**WEST SUSSEX COUNTY COUNCIL
PLANNING SERVICES CONSULTATION**

SUBJECT: Y/68/17/PL - Alterations & extensions to existing redundant garage building to create 1 No. dwelling & associated works. This application affects the character & appearance of the Main Road/Church Road, Yapton Conservation Area & may affect the setting of a Listed Building.

Garage Premises, Main Road, Yapton, West Sussex, BN18 0EA

proposed site & roof plan

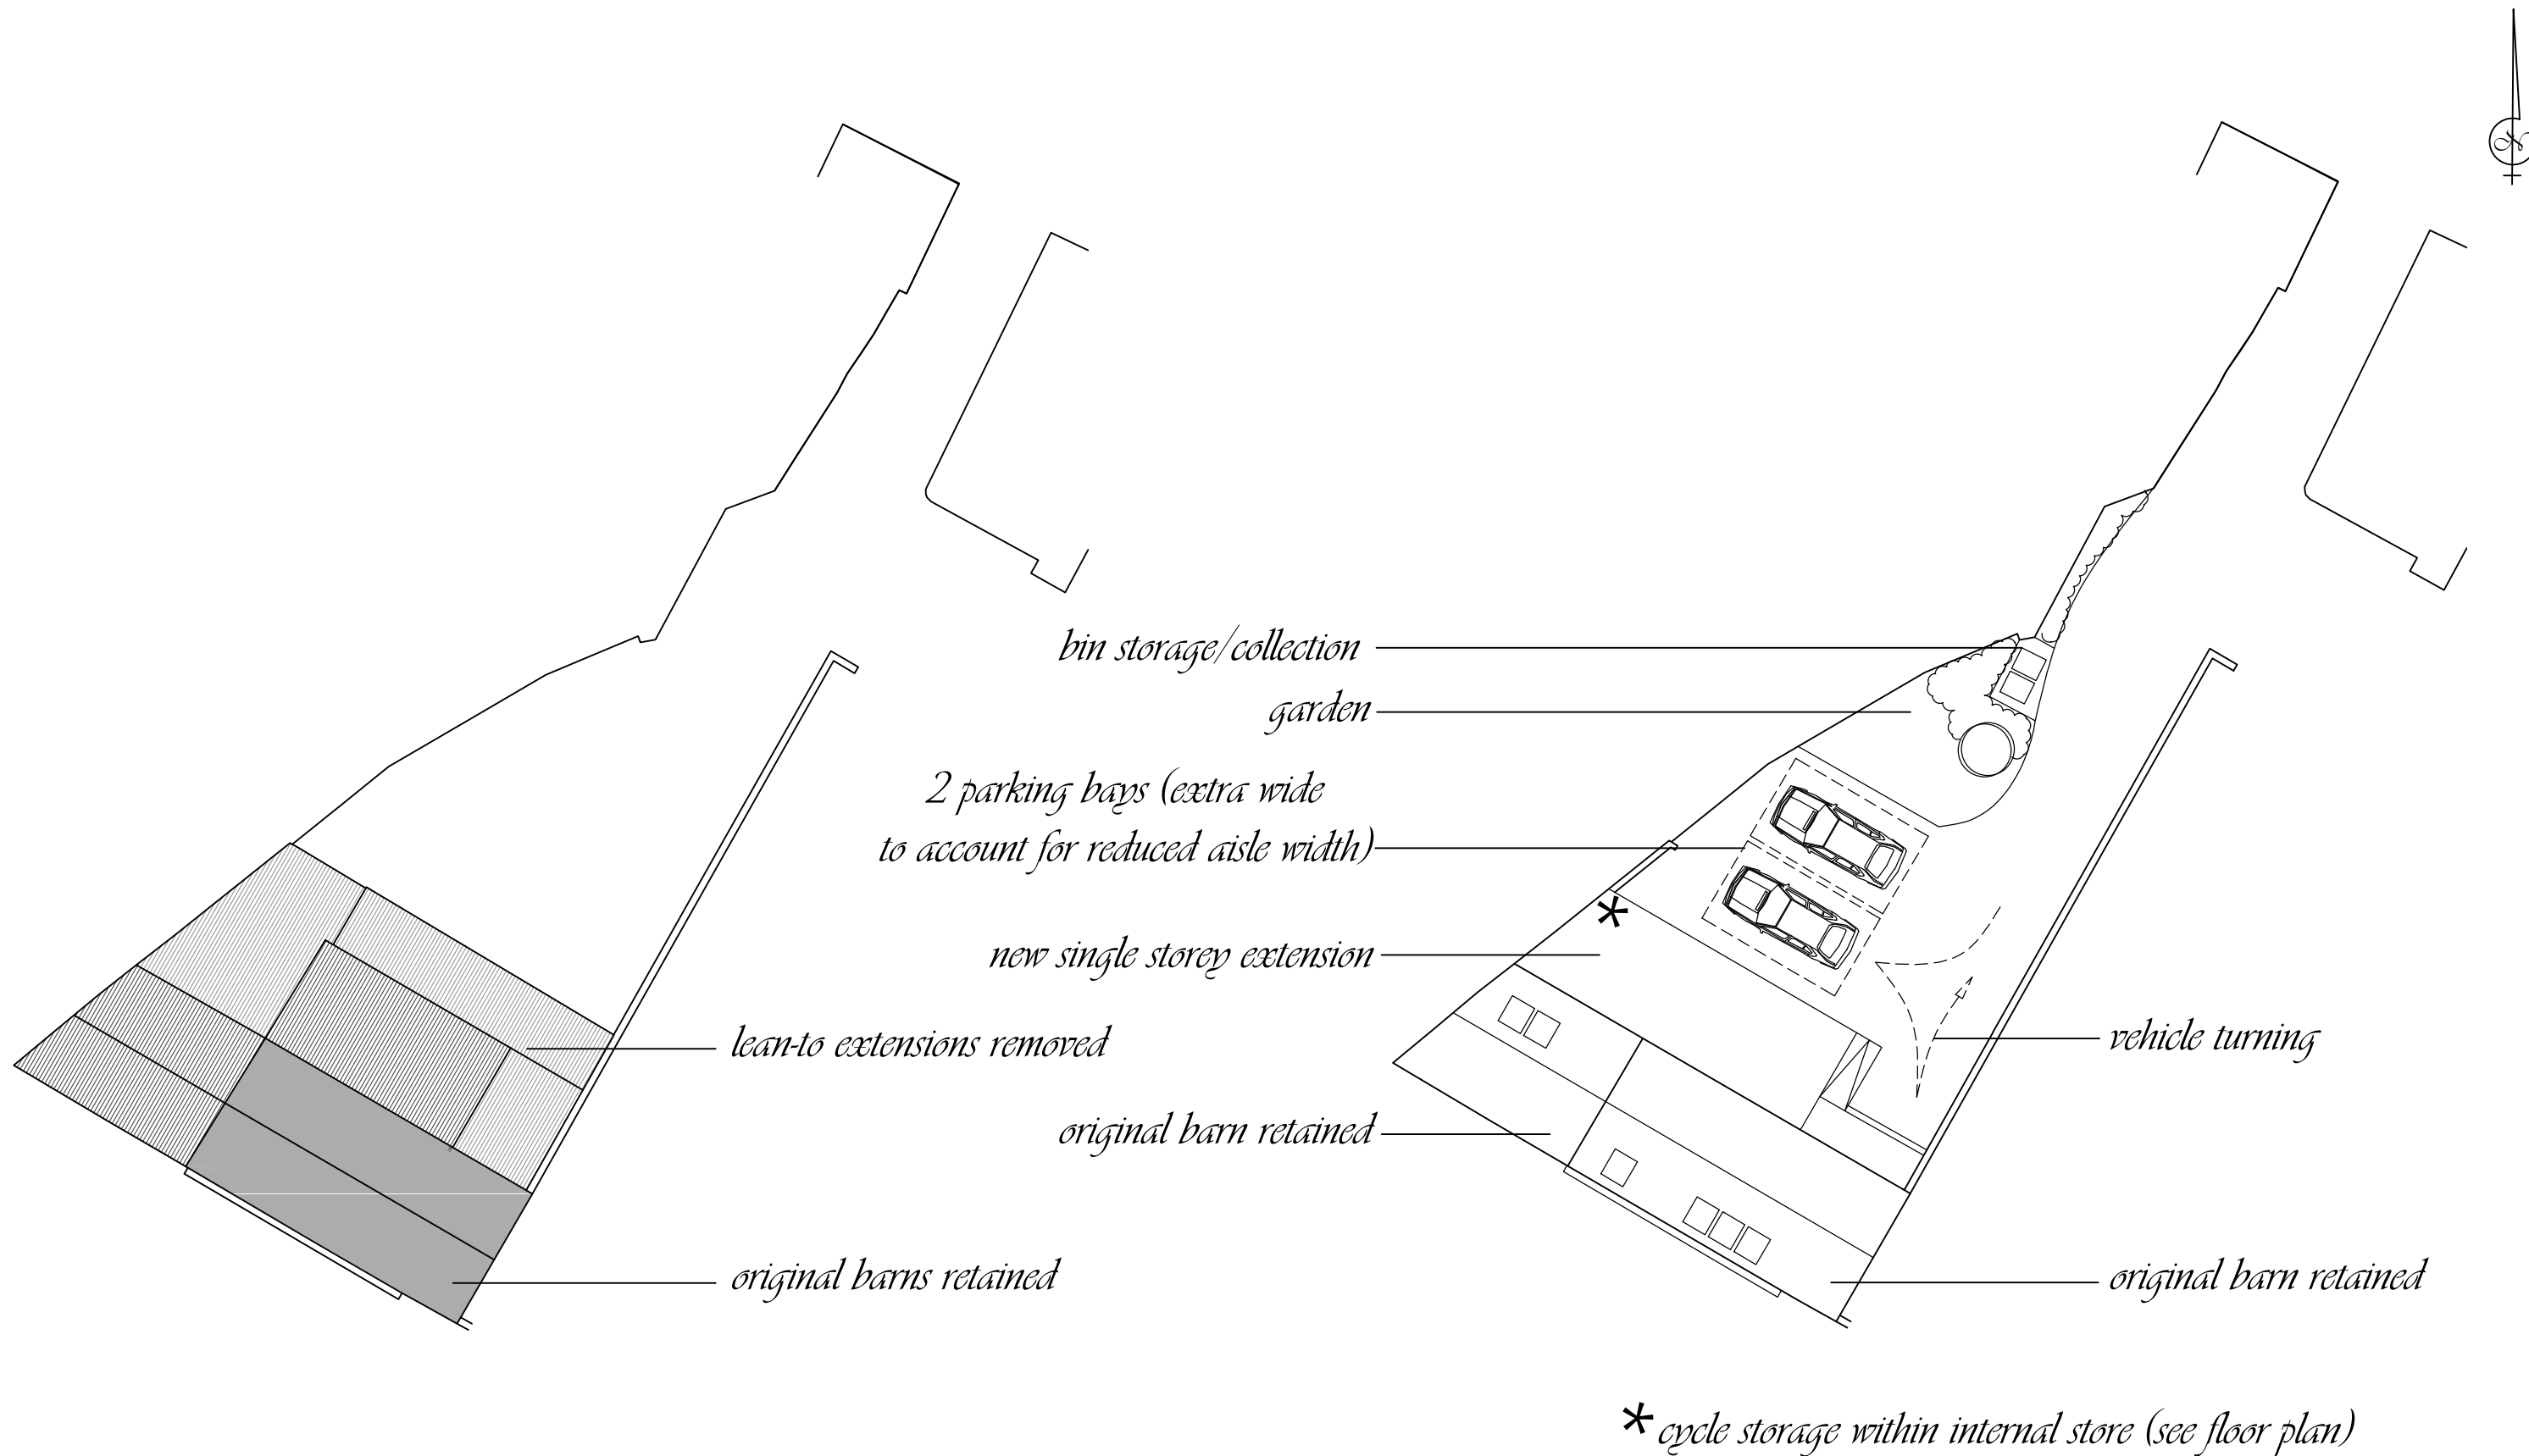
Two car parking spaces are to be provided for the dwelling. On the basis of these being allocated to the use this meets with the level of parking required by the WSCC Car Parking Demand Calculator. The parking spaces are wider to facilitate an improved turn on site as per figure 8.20 Manual for Streets (MfS) which demonstrates a wider parking space can facilitate a manoeuvre from a restricted aisle width.

The LHA are therefore satisfied that sufficient parking and turning will be provided for the dwelling, in order that a car can exit on to the public highway in a forward gear. Secure and covered bicycle storage would also be advised to encourage a sustainable mode of transport in this location where nearby village of Barnham with Train Station and other nearby villages with facilities and amenities would be realistically achievable by the more confident cyclist.

No part of the development shall be first occupied until the vehicle parking and turning spaces have been constructed in accordance with the approved plan. These spaces shall thereafter be retained for their designated use.
